From: Contact Centre (CRM) <contact@ribblevalley.gov.uk>
Sent: 28 January 2024 11:29
To: Planning
Subject: Planning Application Comments - 3/2023/0488 FS-Case-581134526

Planning Application Reference No.: 3/2023/0488

Address of Development: Jenny Press, Back York Street

Proposed Elevations 1:100 @ A3

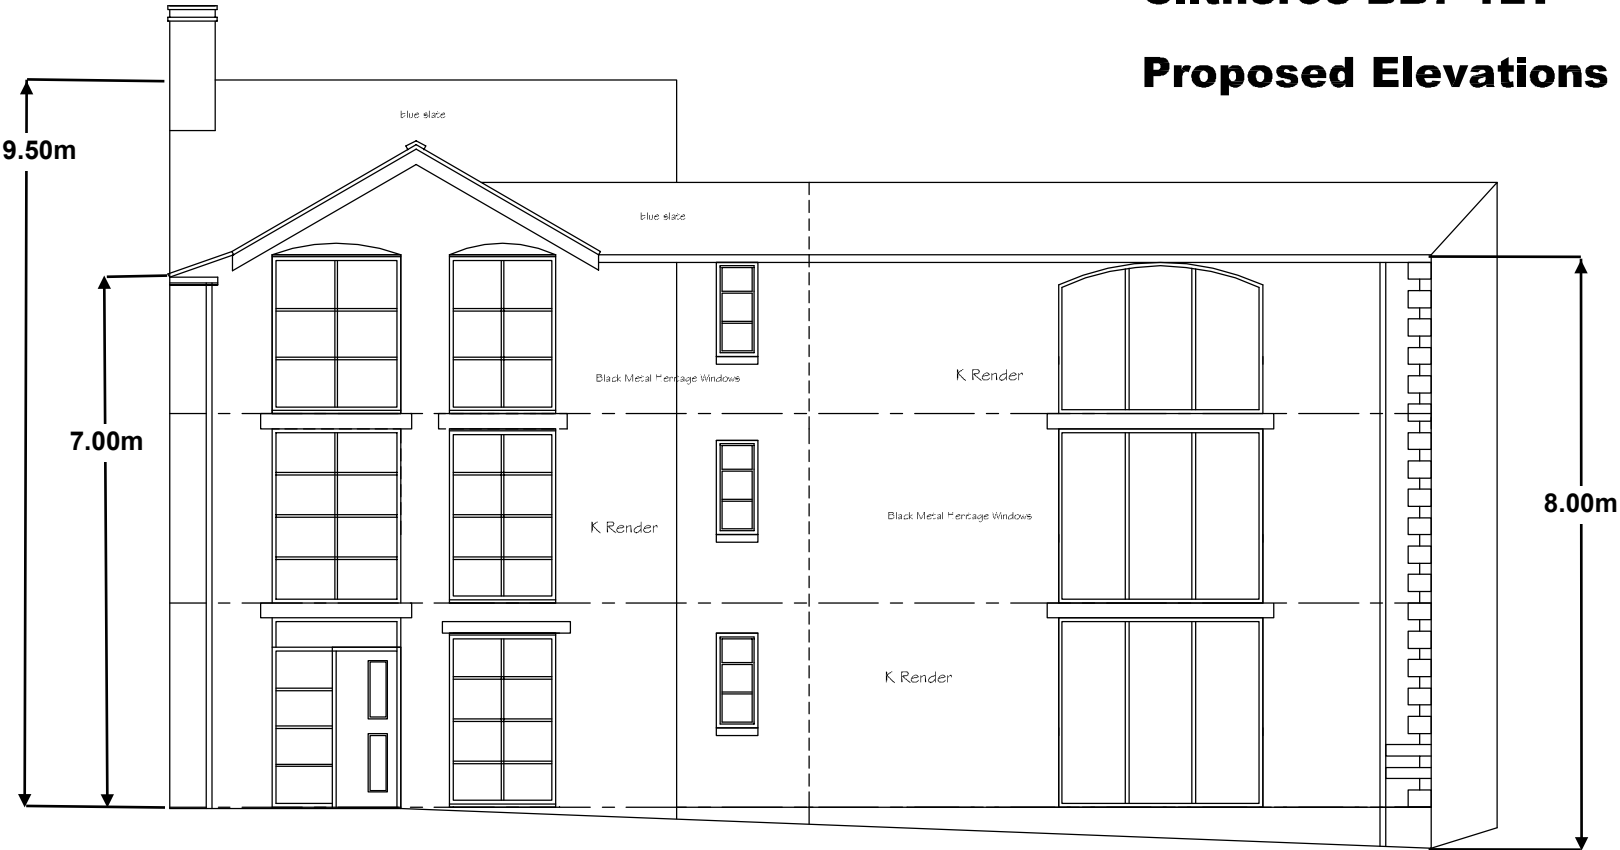
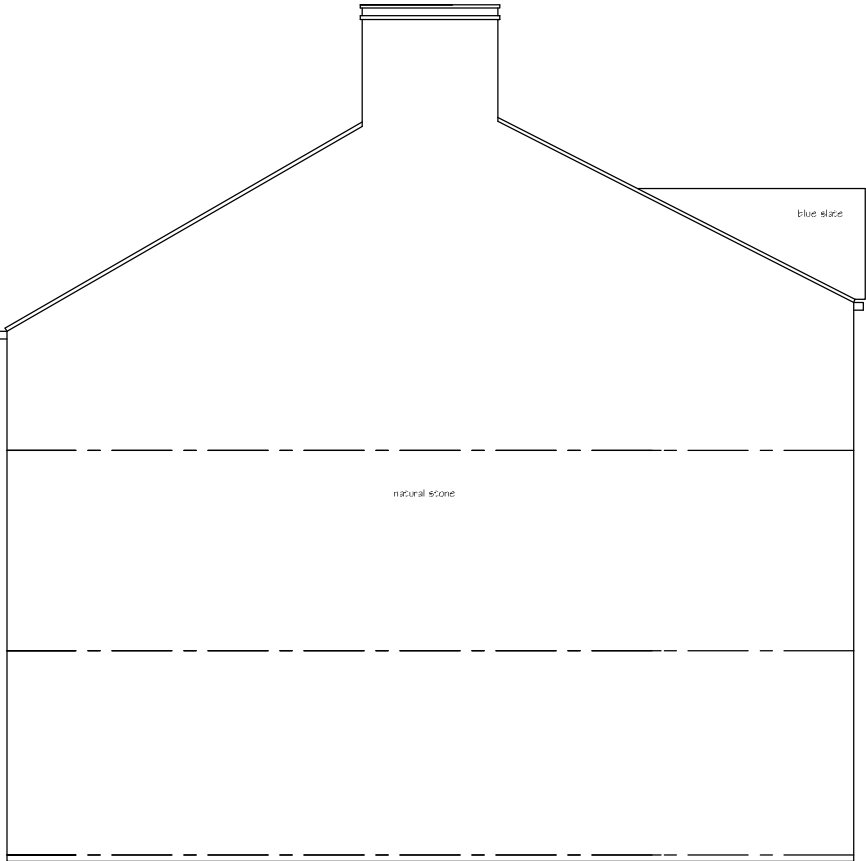
We have particular concerns regarding the additional storey to the brick section of the proposed new building. This entirely changes the character of the historic building within the conservation area, and impacts the right to enjoy

[REDACTED] Whilst we welcome the improvements it would seem more appropriate that a degree of the original history ought to be retained, such as the hoist on the front façade. The loss of this type of detail would lead to the erosion of Clitheroe's distinctive architectural charm.
